Application no: 18/CH0010/Preapp

Location: Land at Promised Land Farm, Wendlebury Rd, Bicester OX25 2PA.

Transport Schedule

Comments below are in response to both the transport pre-application enquiry made directly to OCC and the CDC pre-application (Ref: 18/00287/PREAPP).

JOB TITLE		BICESTER CATALYST		CLIENT		ALBION LAND	
DRAWING TITLE							
WENDLEBURY ROAD SITE ACCESS ROUNDABOUT							
SCALE	DRAWN BY	DATE	DRAWING No	REVISION			
1:500@A1	RJM	03/05/19	19539-11-02	A

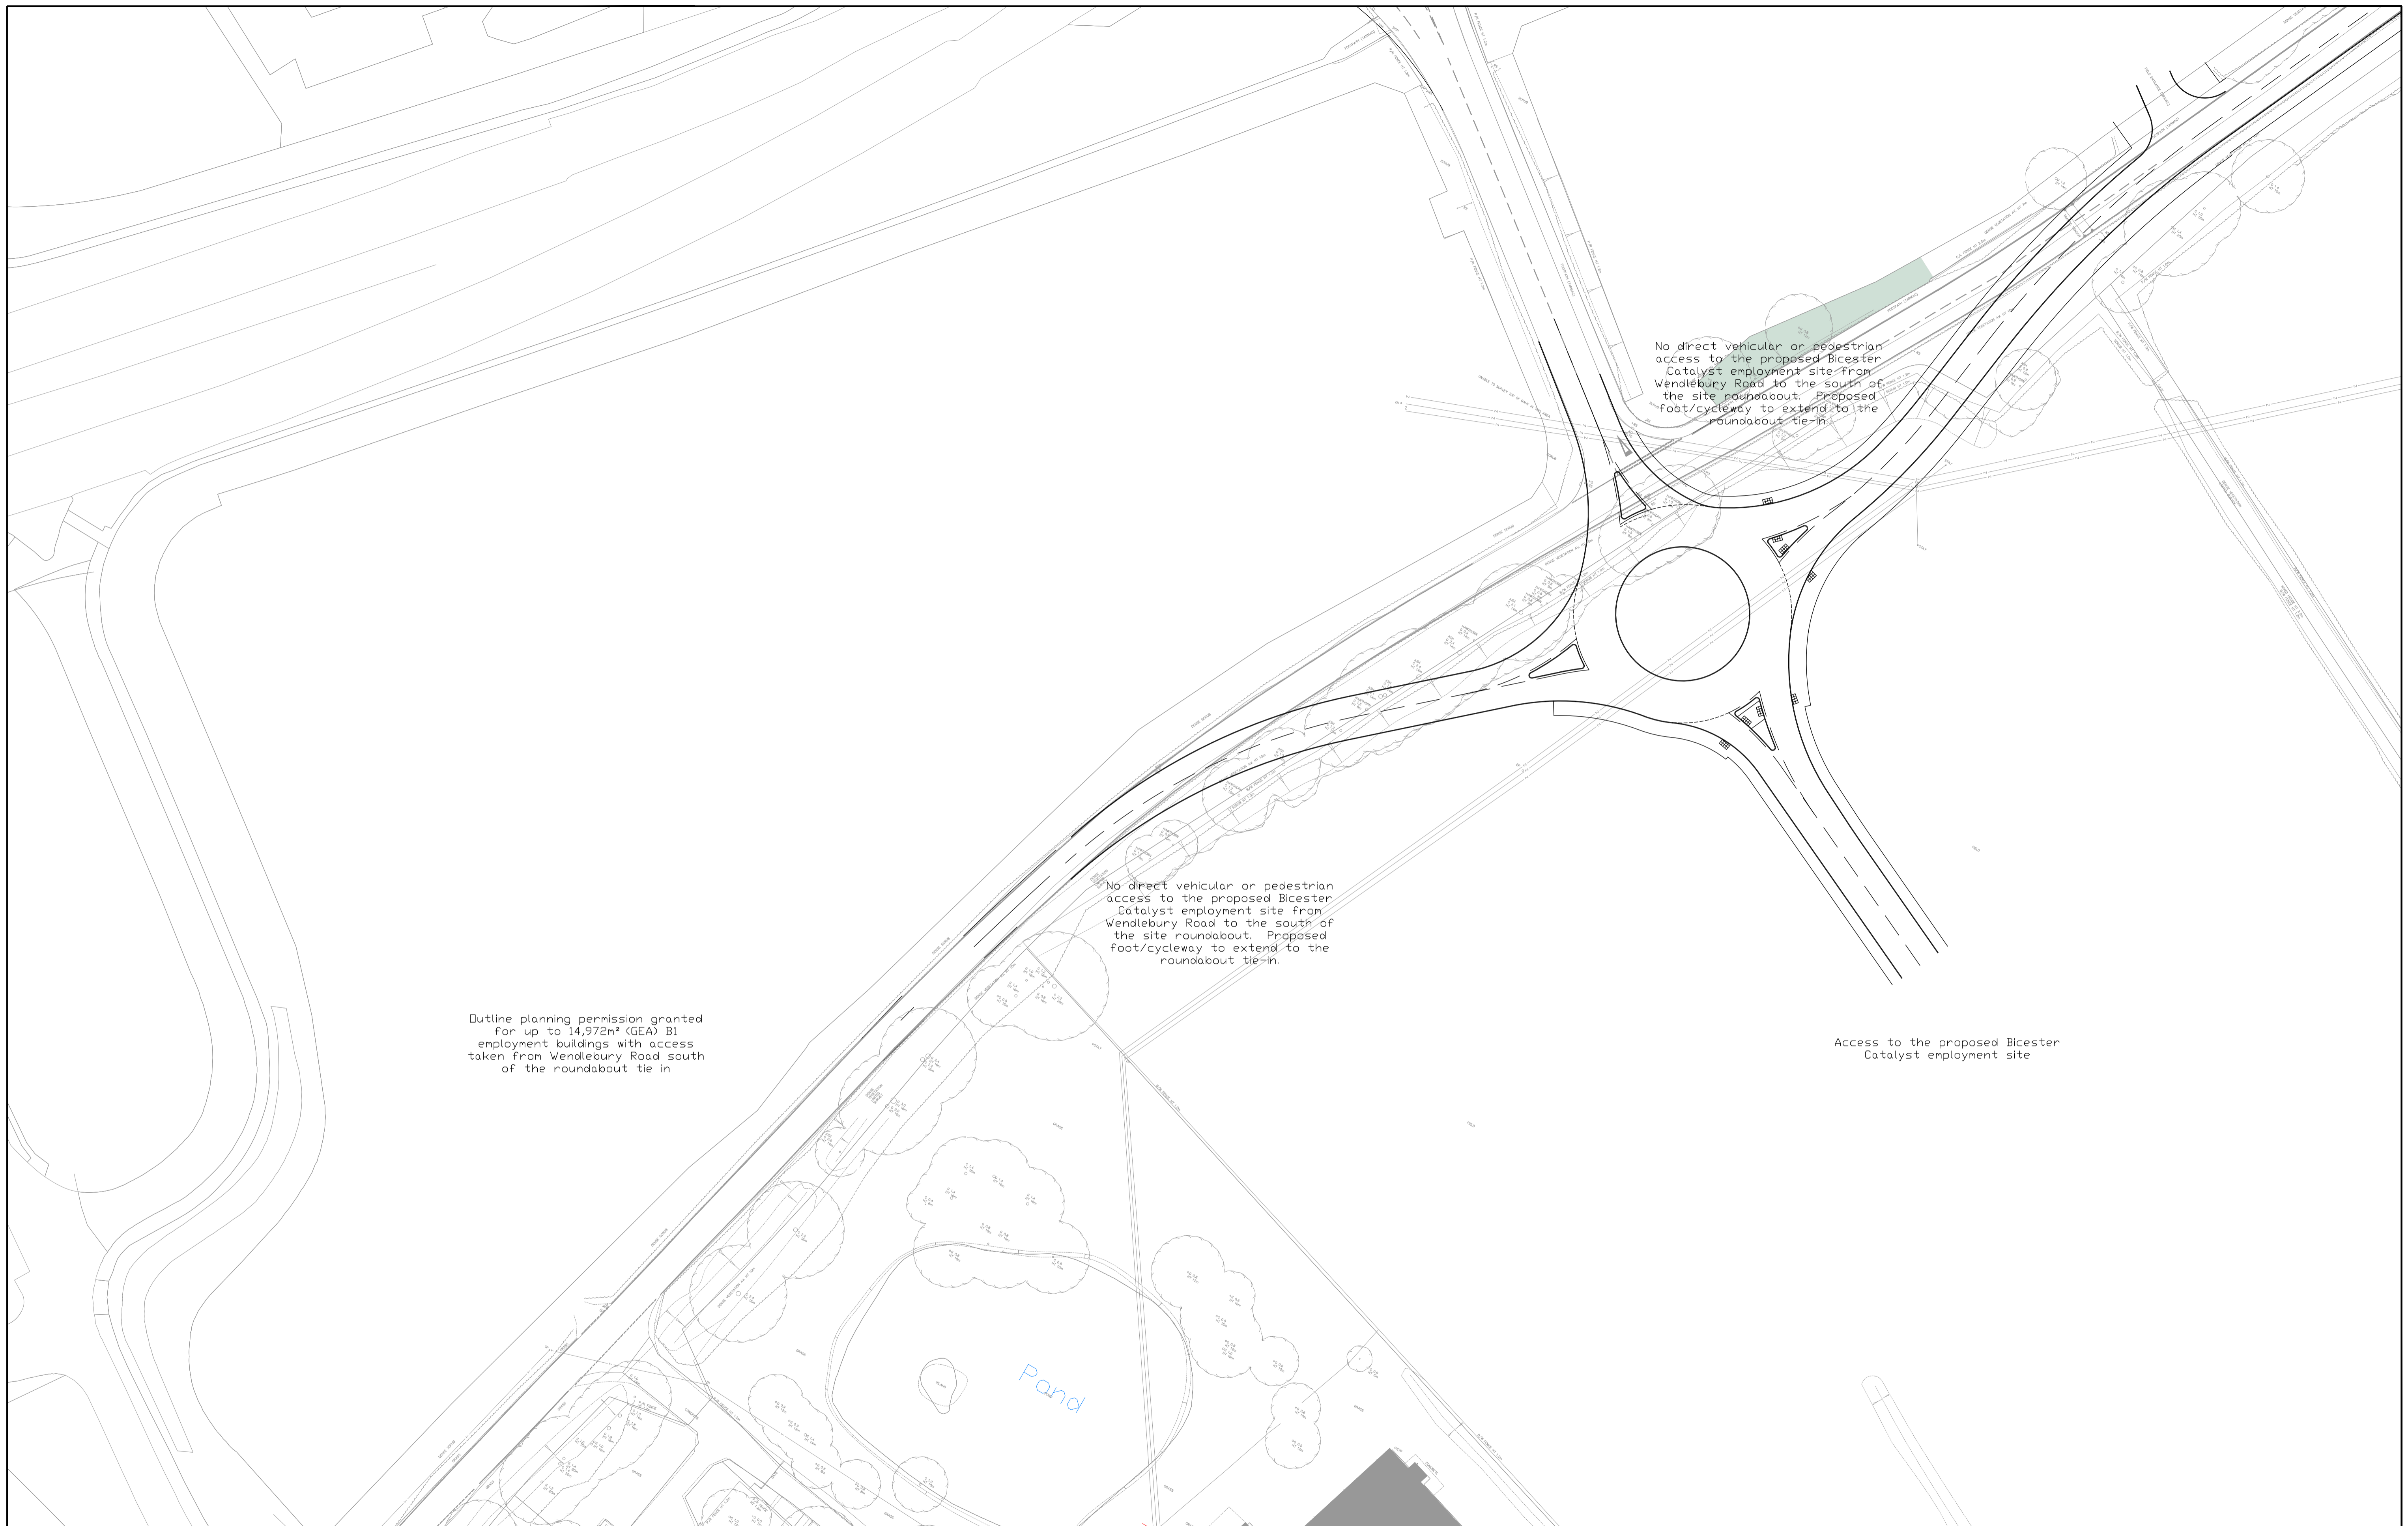
Vehicular and principal pedestrian/cycle access is proposed to come off Wendlebury Road with a formation of a new 4-arm roundabout. The new roundabout would serve the Wendlebury Road (North and South arms), site access and the Vendee Drive roundabout link will form the east and west arms respectively.

Para 8.4 suggests that the proposed roundabout that would form access onto Wendlebury Road has already been capacity tested which has confirmed that traffic can be accommodated at the roundabout. Modelling results are hence required for this roundabout.

development due to its width and apparent construction. For this to be acceptable, an upgrade of Wendlebury Road will be required between the A41/Wendlebury junction and the proposed site access. The upgrade shall be required to make it suitable for the increased traffic and also provision for pedestrian and cycle access.
